Our ref: DOC20/336068-17

Your ref: SSD-9526

Maxwell Underground Coal Mine Project (SSD 9526) – BCD's Response to Malabar Coal's Correspondence - BAM requirements for Threatened Flora Assessment

Date: 14 July 2020

Figure 2 Field Survey Details

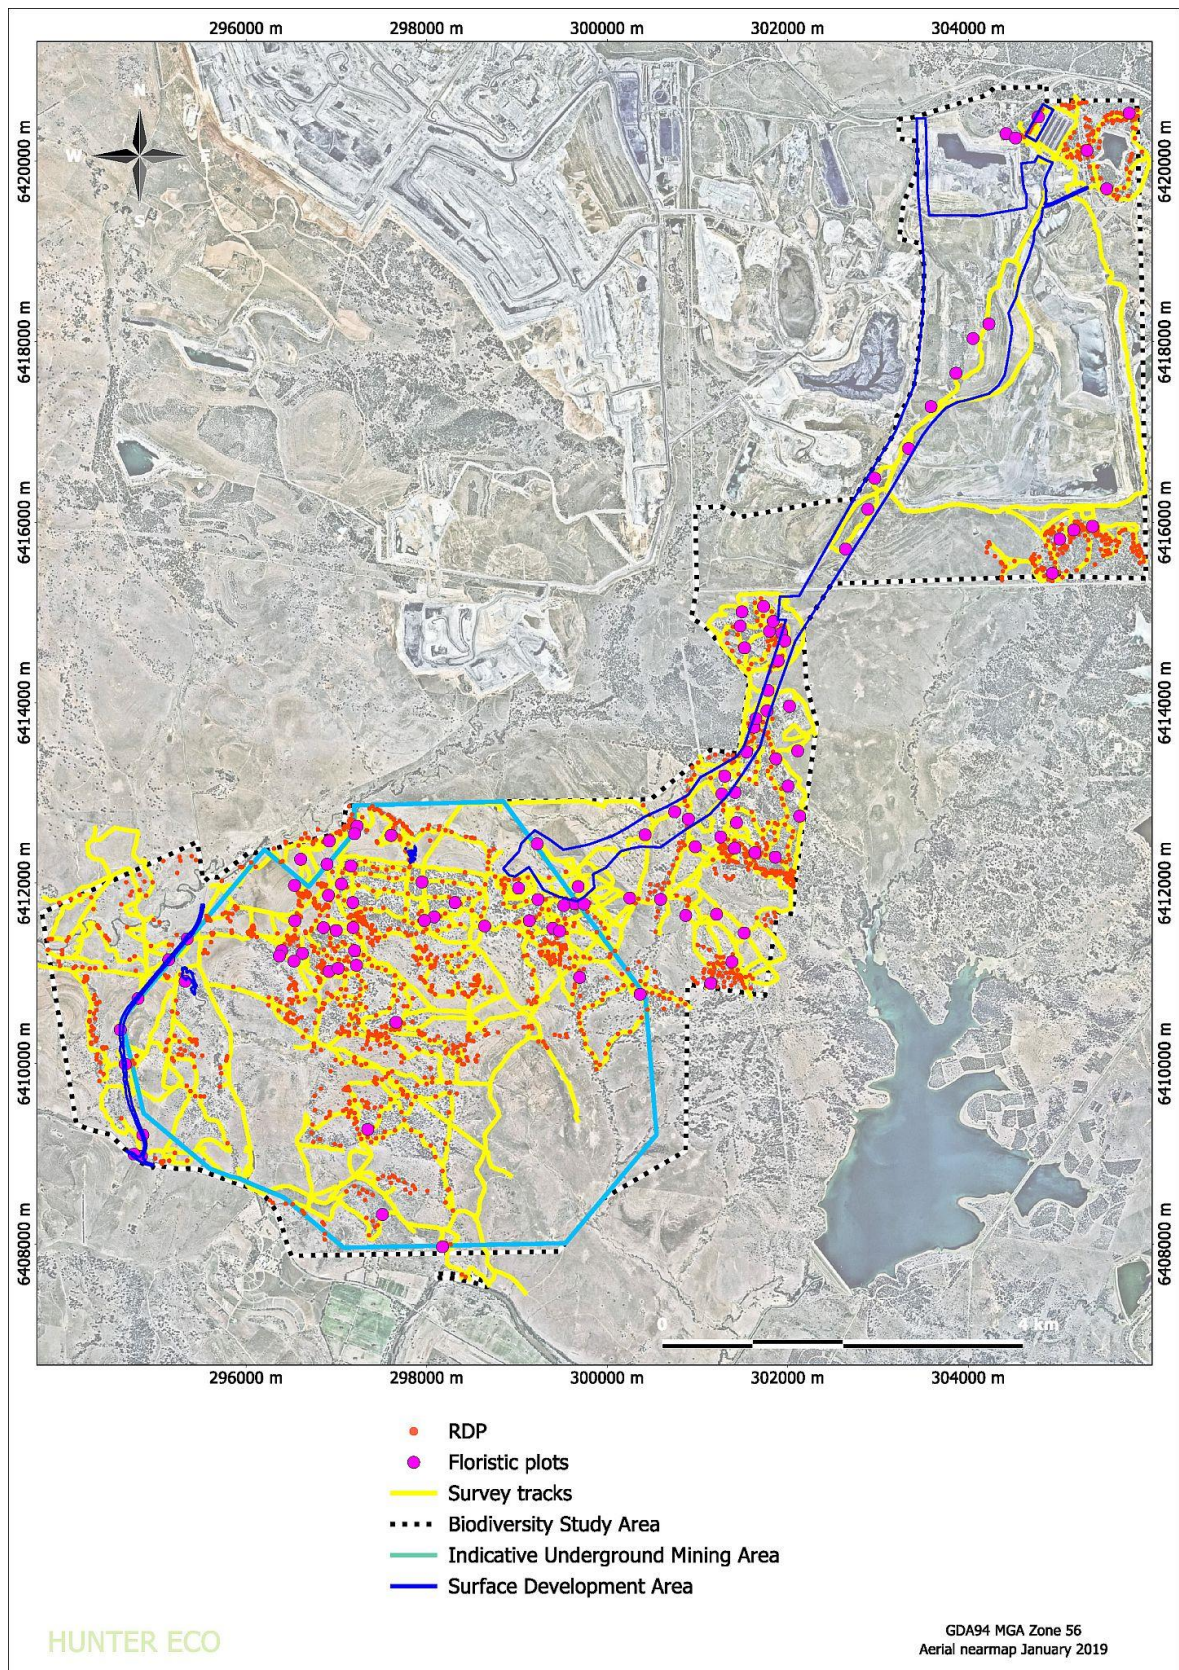
The map of the targeted flora surveys, Figure 2 in Dr. Driscoll's letter, does not appear to be compliant with current guidelines. It appears to show the transects as random meanders rather than parallel tracks, with no obvious spacing or systematic sampling. Based on the coarse map scale attached to this figure, transects are not systematic, are spaced at varying widths without any obvious reasoning and thus they appear to miss large areas of the Project Area, including potential habitat for some threatened flora (e.g. derived grasslands for *Diuris tricolor*).

BCD recommends that the proponent demonstrates how the targeted flora surveys in the BDAR were undertaken in accordance with *NSW Guide to Surveying Threatened Plants* (OEH 2016). This would include details on the survey methods used, the survey effort (including timing and seasonality), and the habitats searched. In instances where the BAM accredited assessor deviates from these guidelines then appropriate justification is to be provided.
